Re 3/2024/0029.

31 Chapel Brow Leyland Preston PR25 3NH
 Tel 01772 467404 E Mail info@pwlarchitecture.com
 1:100@A3 1424-PL07C

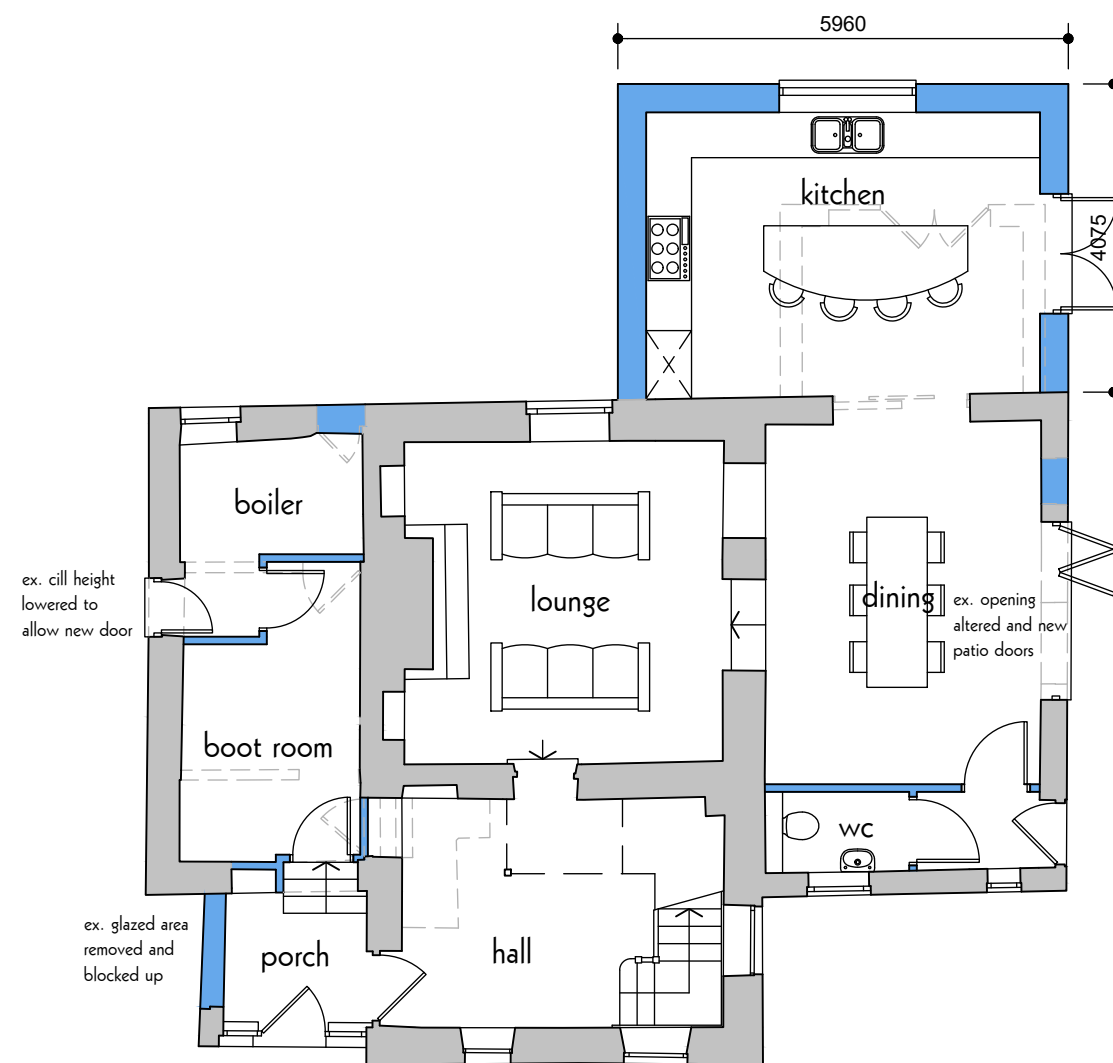
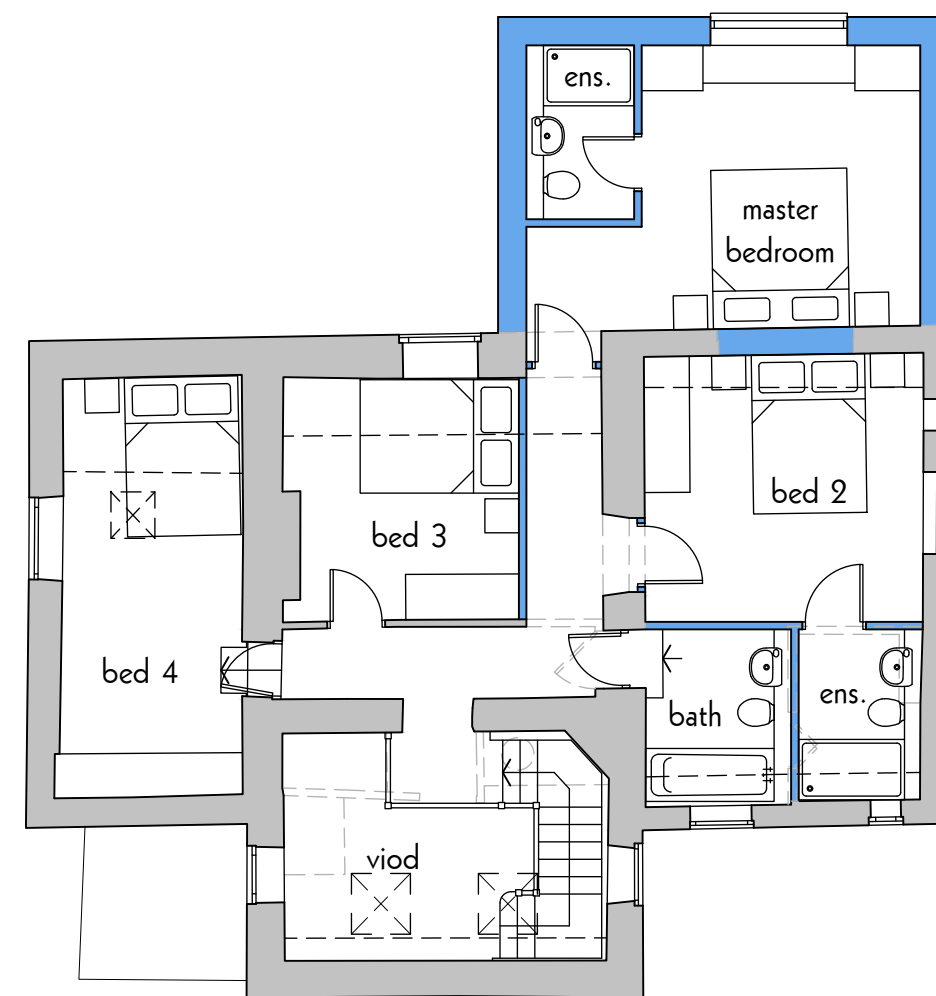
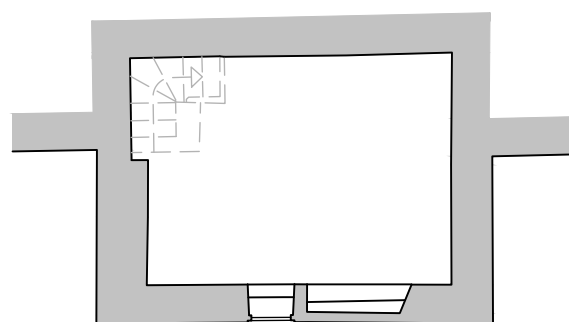
The land levels are being raised yet again with top soil and the side of the house bordering the river is over a meter higher than the original property, furthermore, the window & door plans are incorrect, the property has had new windows cut and others removed which are not shown on the registered plans.

Drwg No
1424-PL06E

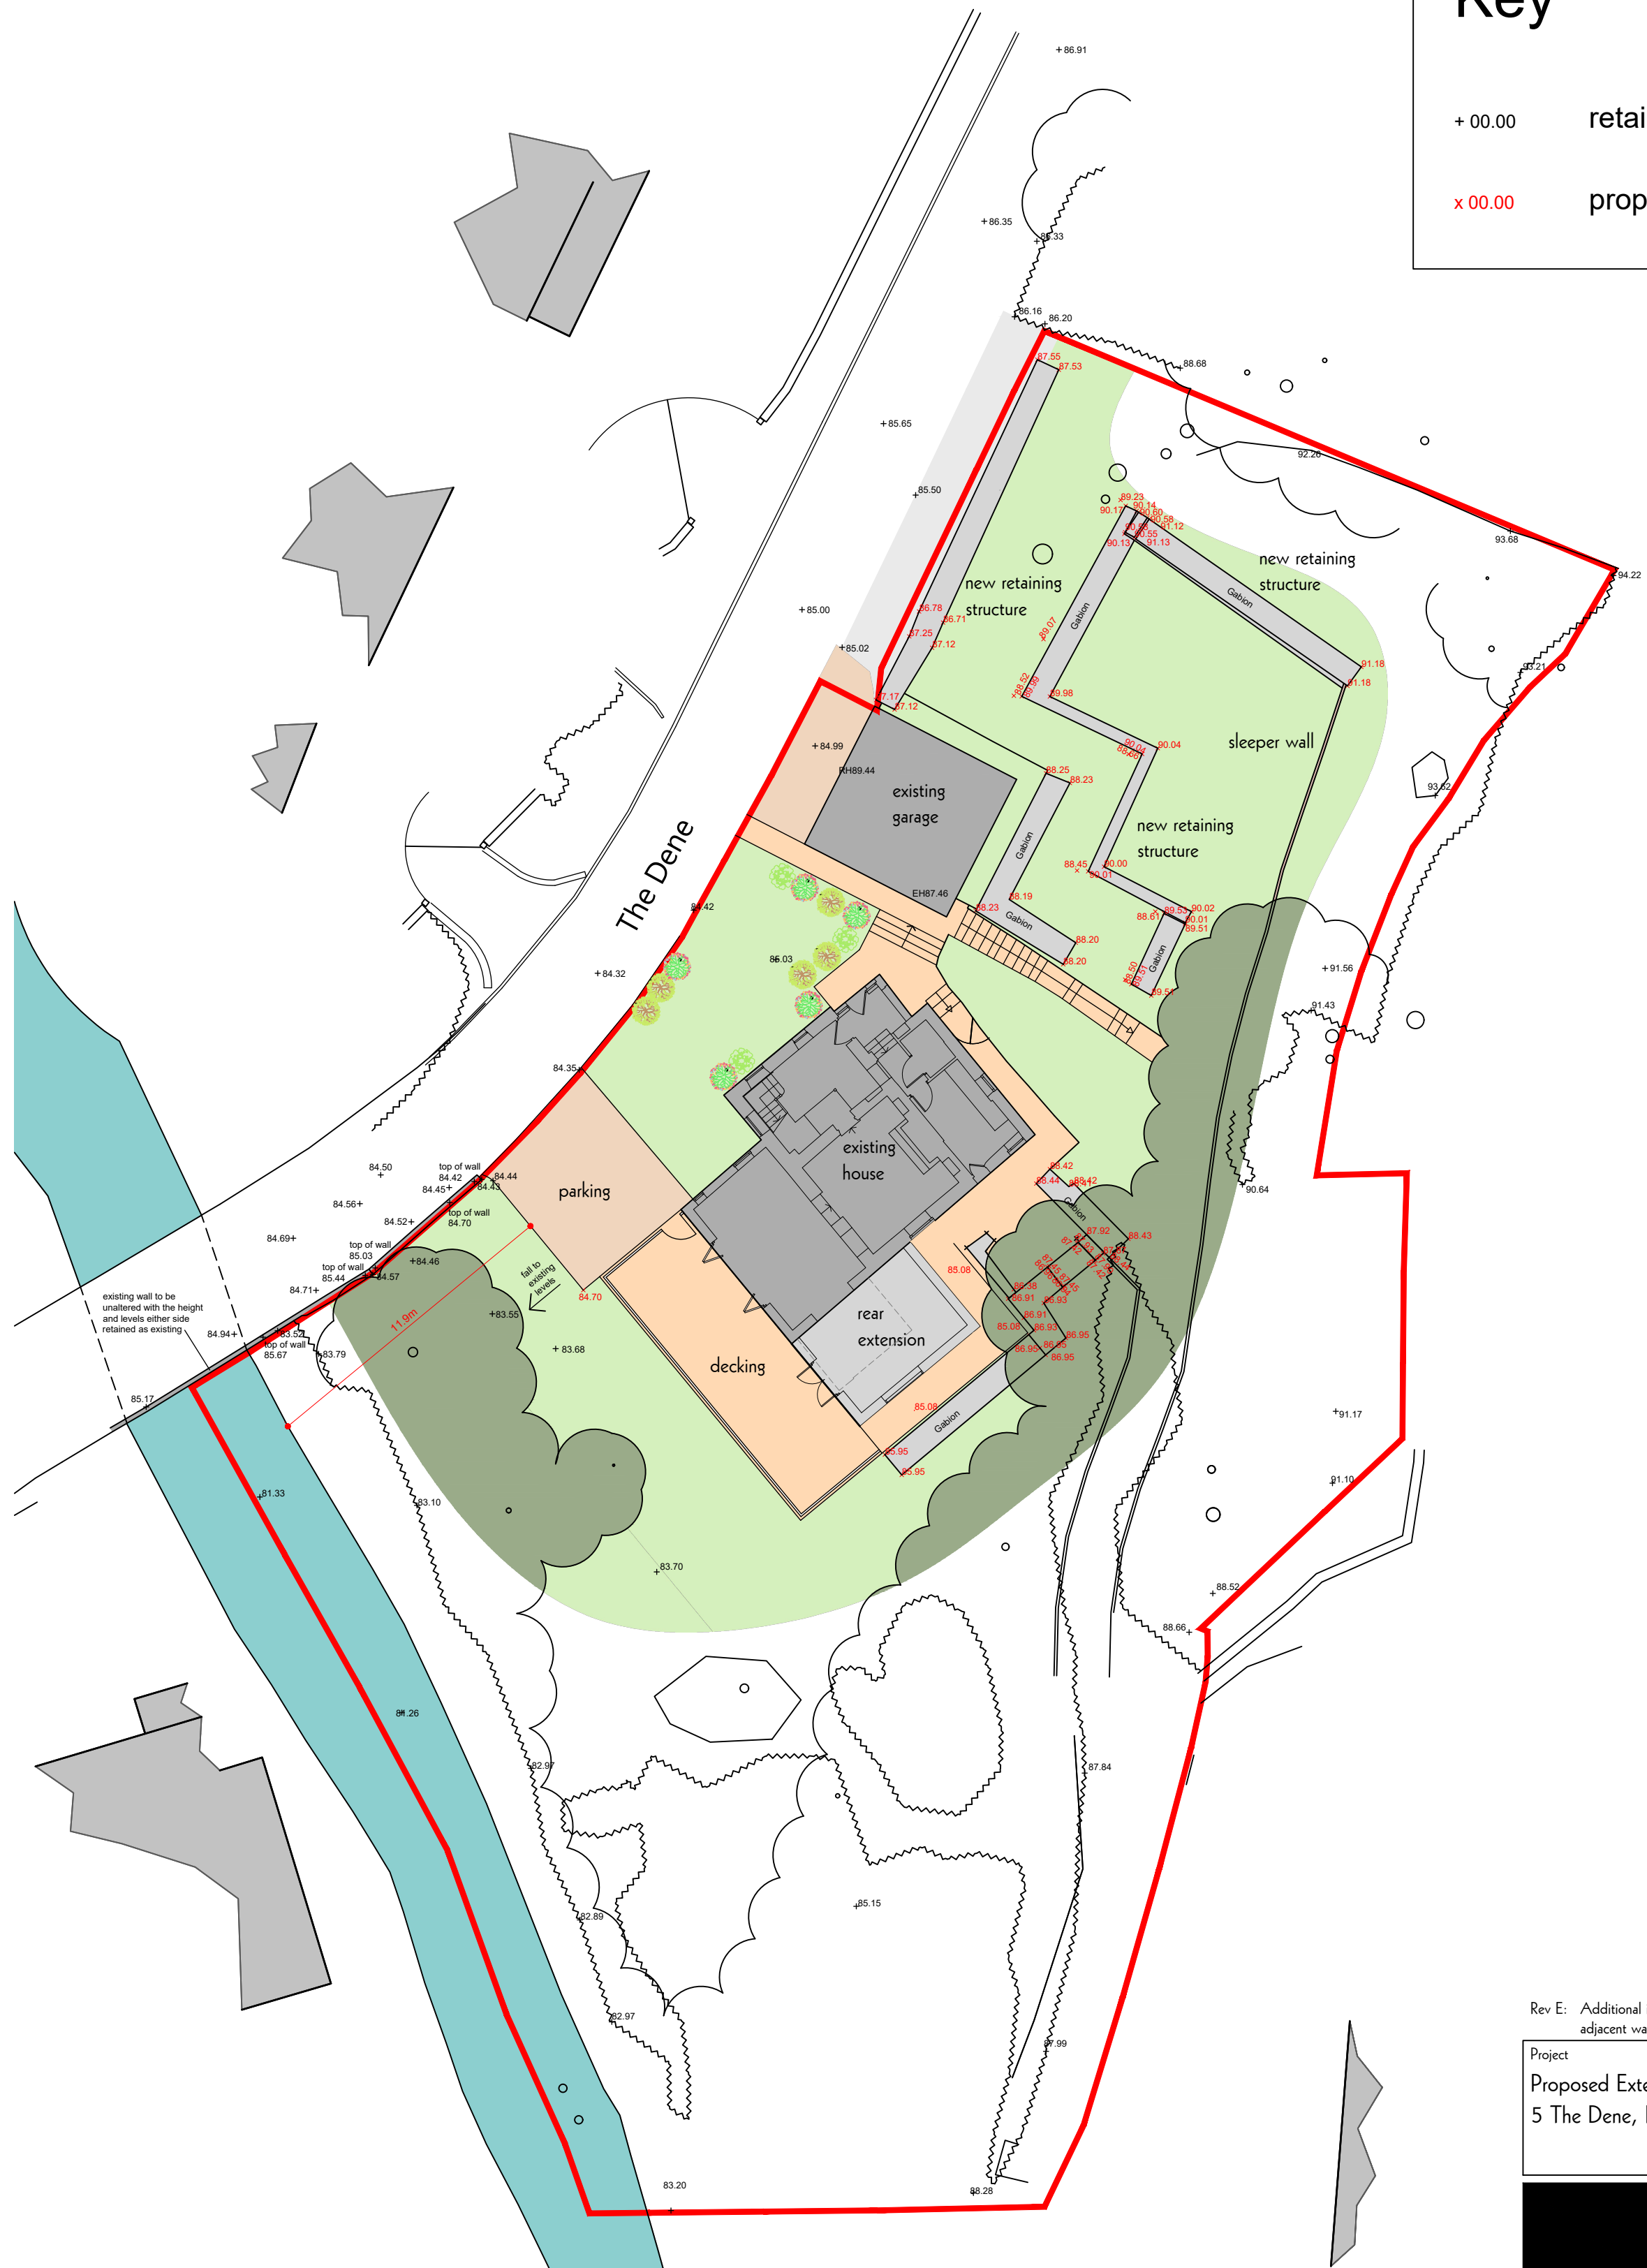
In regard to the above planning application being heard, could you please bear in mind when considering this application, that the plans submitted showing the property before & after work regarding land levels & property layout are WRONG!
